Application for Removal or Variation of a Condition following Grant of Planning Permission

PROPOSED DEMOLITION OF COMMERCIAL UNIT & ERECTION OF SINGLE STOREYDWELLING

22/01351/MNR

Condition 2- approved plans and documents

DRAWING TITLE  
Ground Floor Plan as Proposed

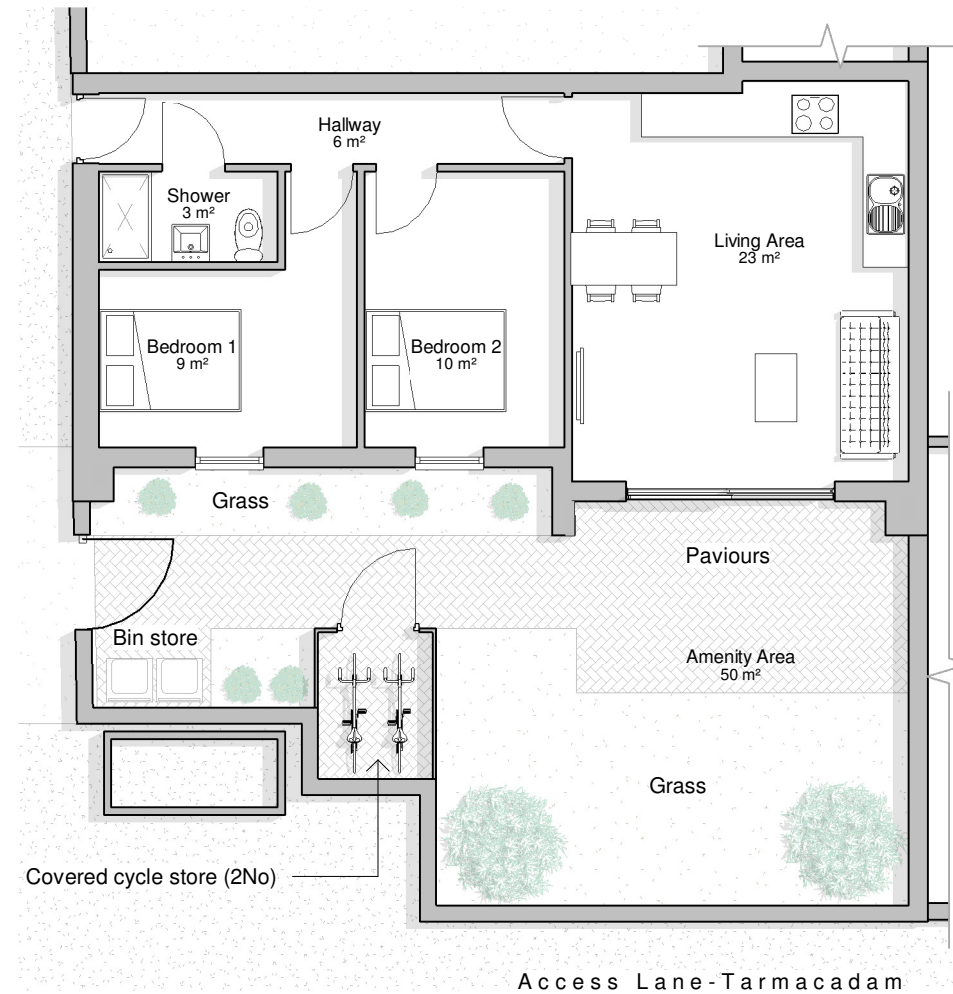
P713a L_200 - Ground Floor Plan as Proposed to be replaced with P713a L_200_Rev A - Ground Floor Plan as Proposed

DRAWING TITLE
 Site Plan as Proposed

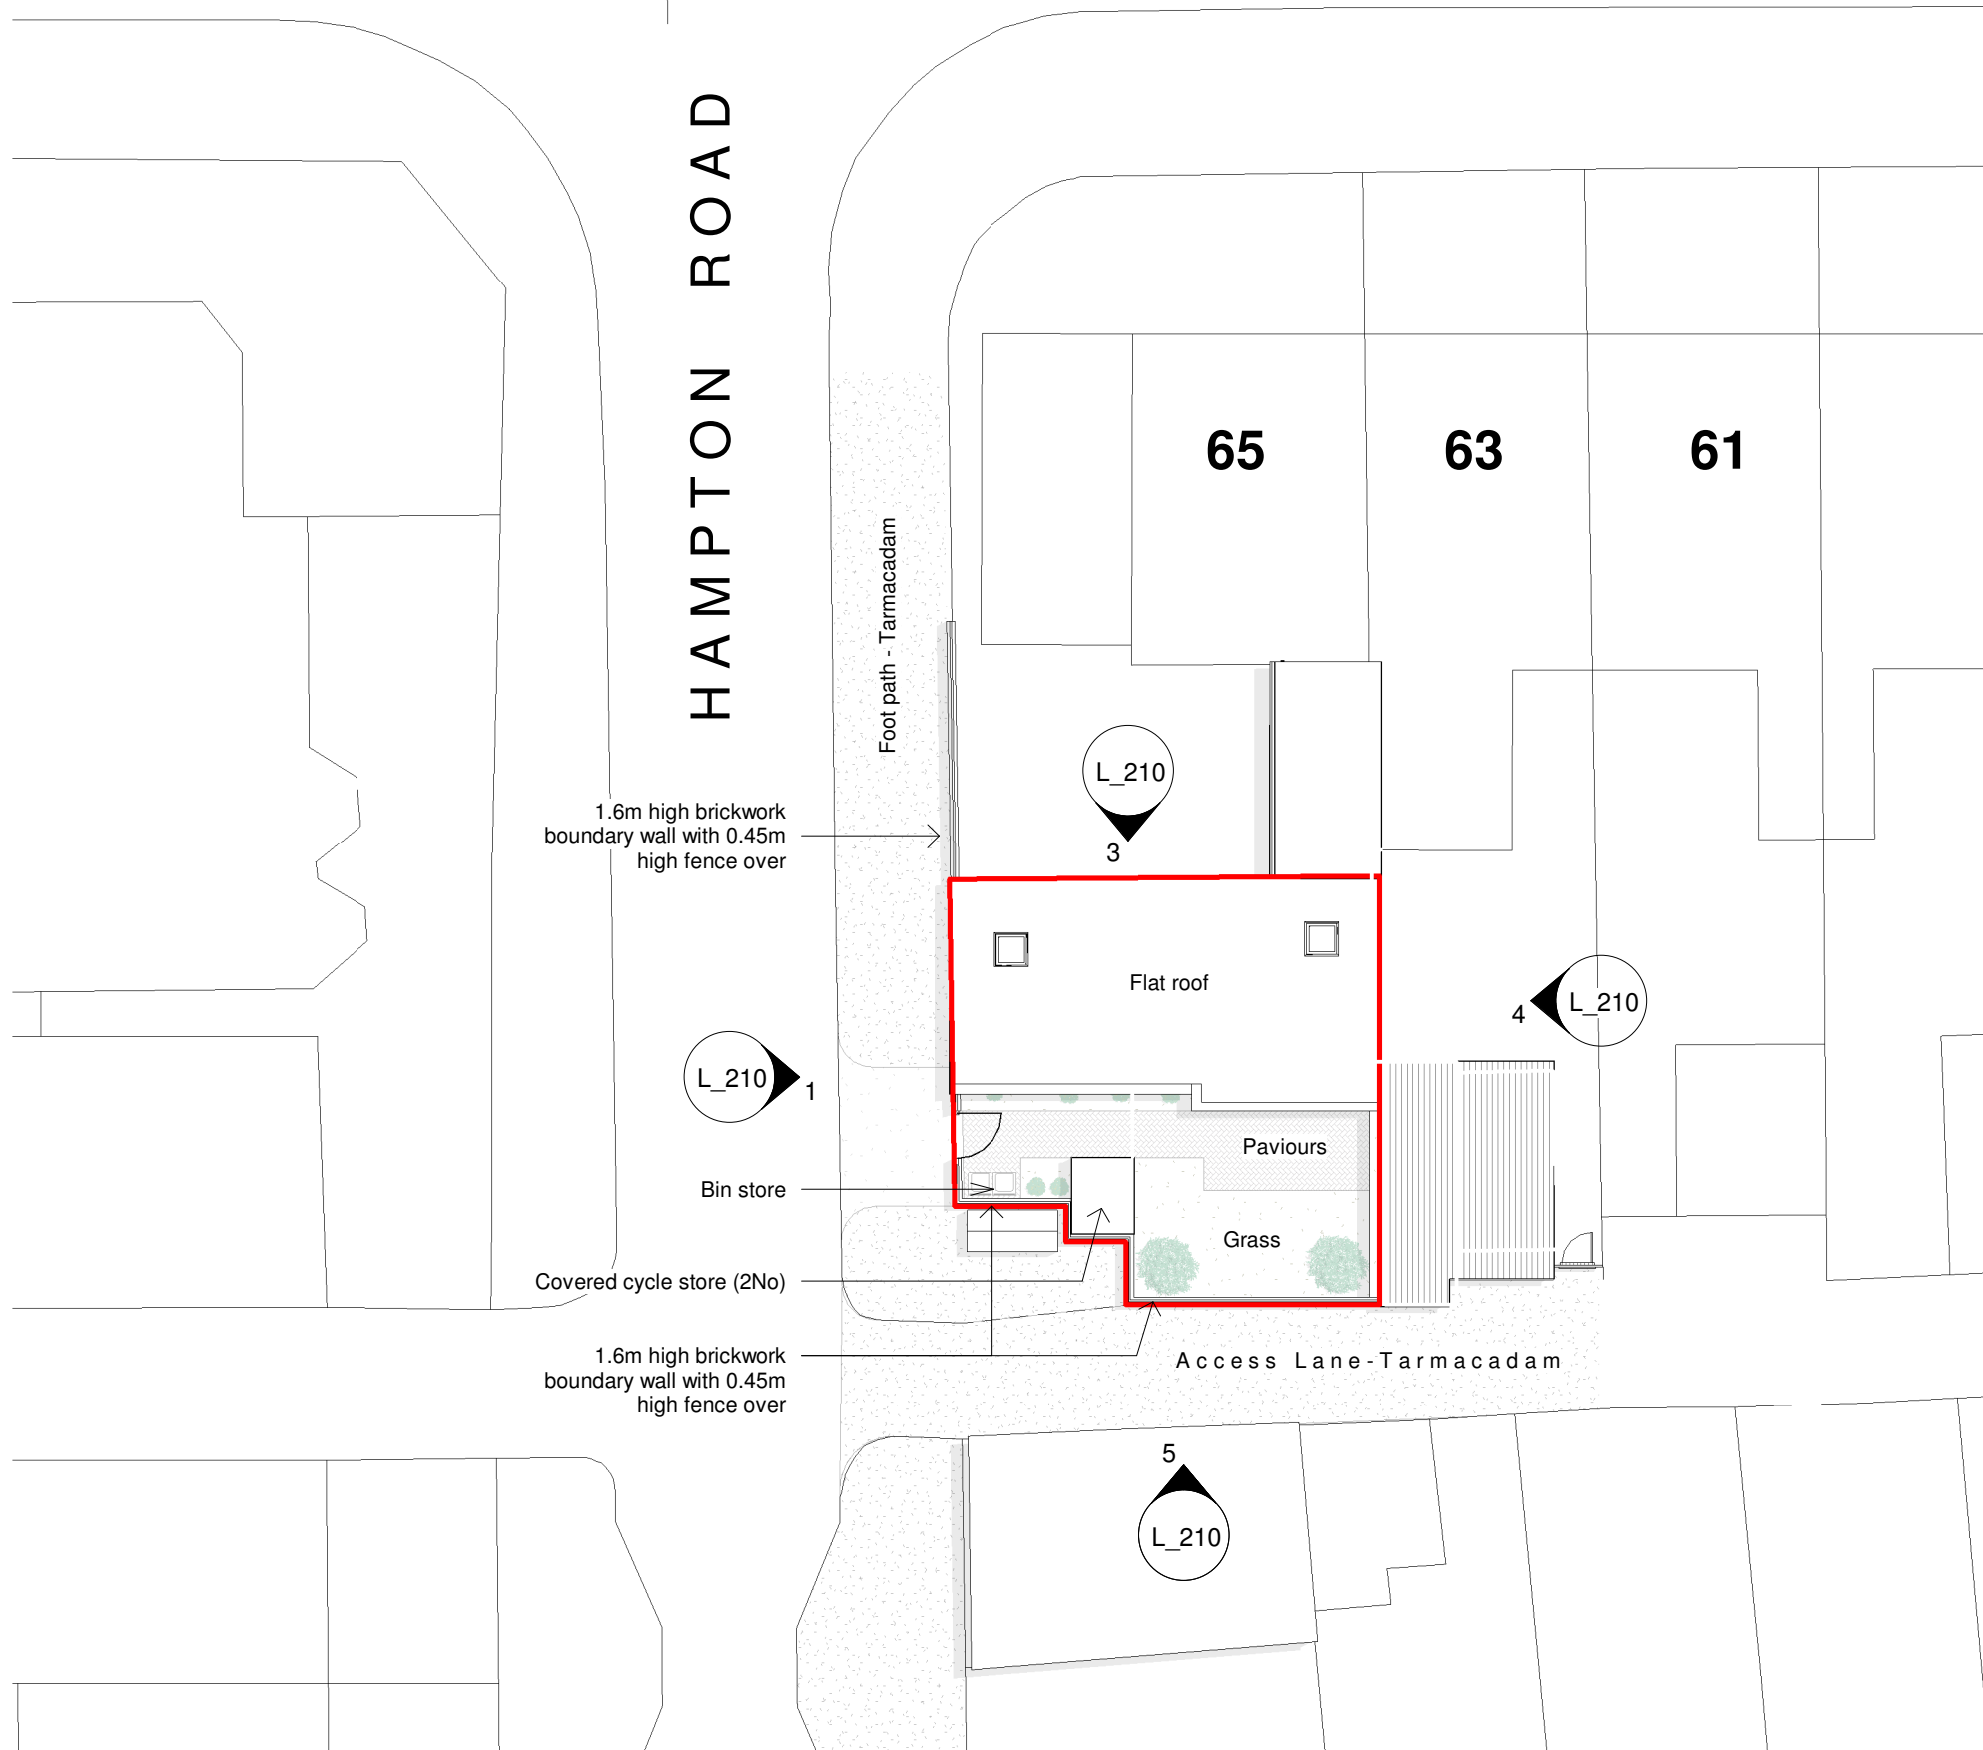
P713a L_003 - Site Plan as Proposed to be replaced with P713a L_003_Rev A - Site Plan as Proposed

DRAWING TITLE
 Perspective View as Proposed

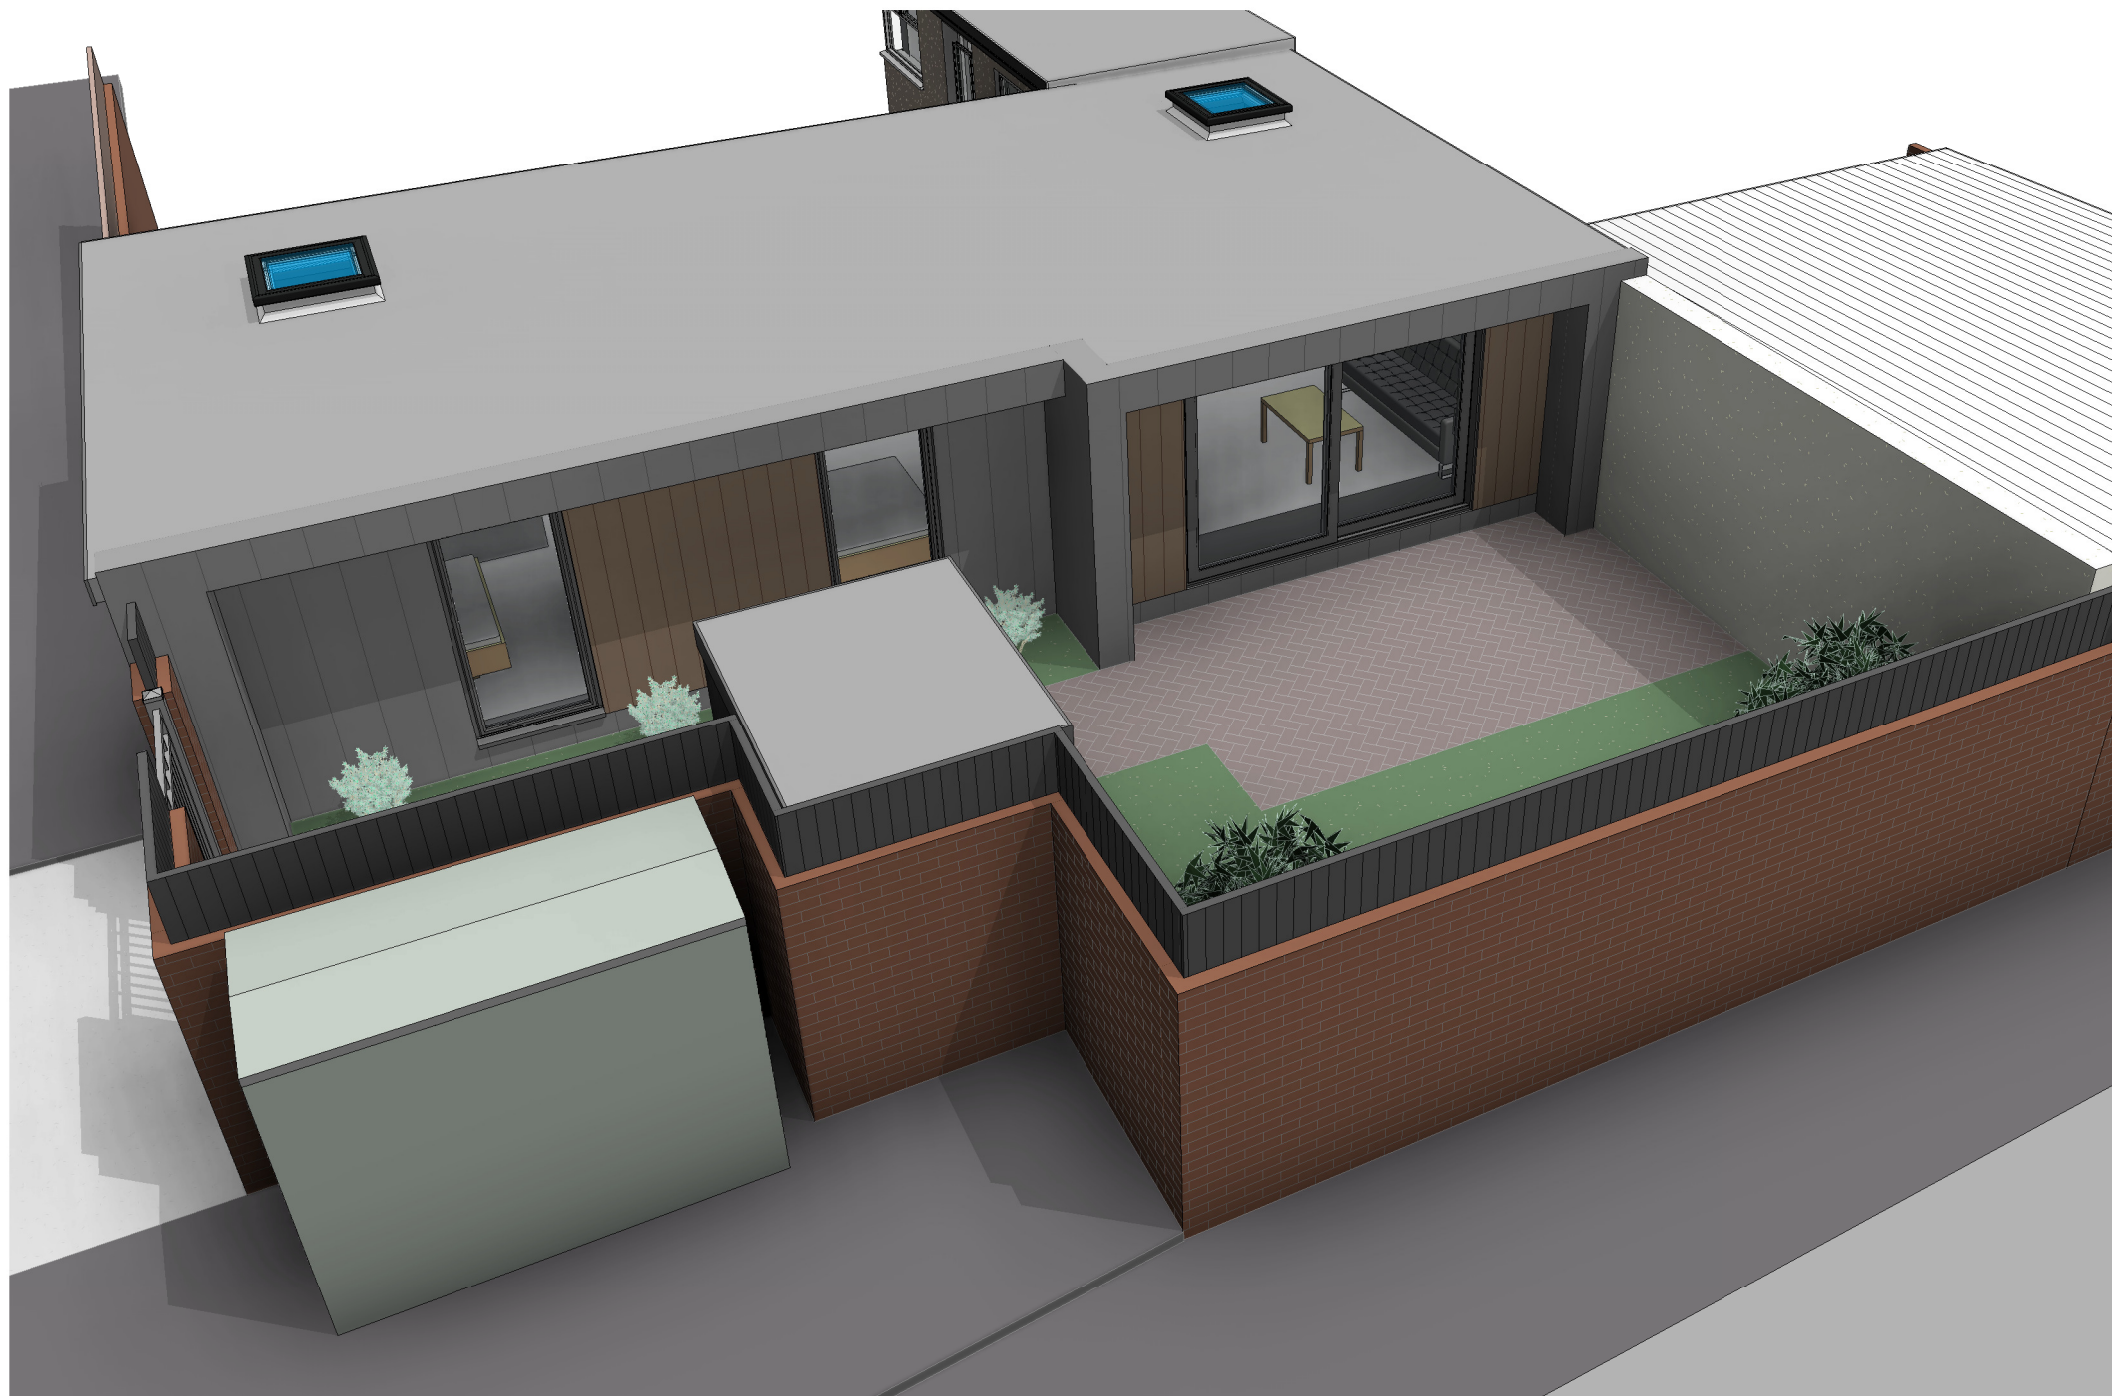
P713a L_220 Rev A - Perspective View as Proposed to be replaced with P713a L_220 Rev B - Perspective View
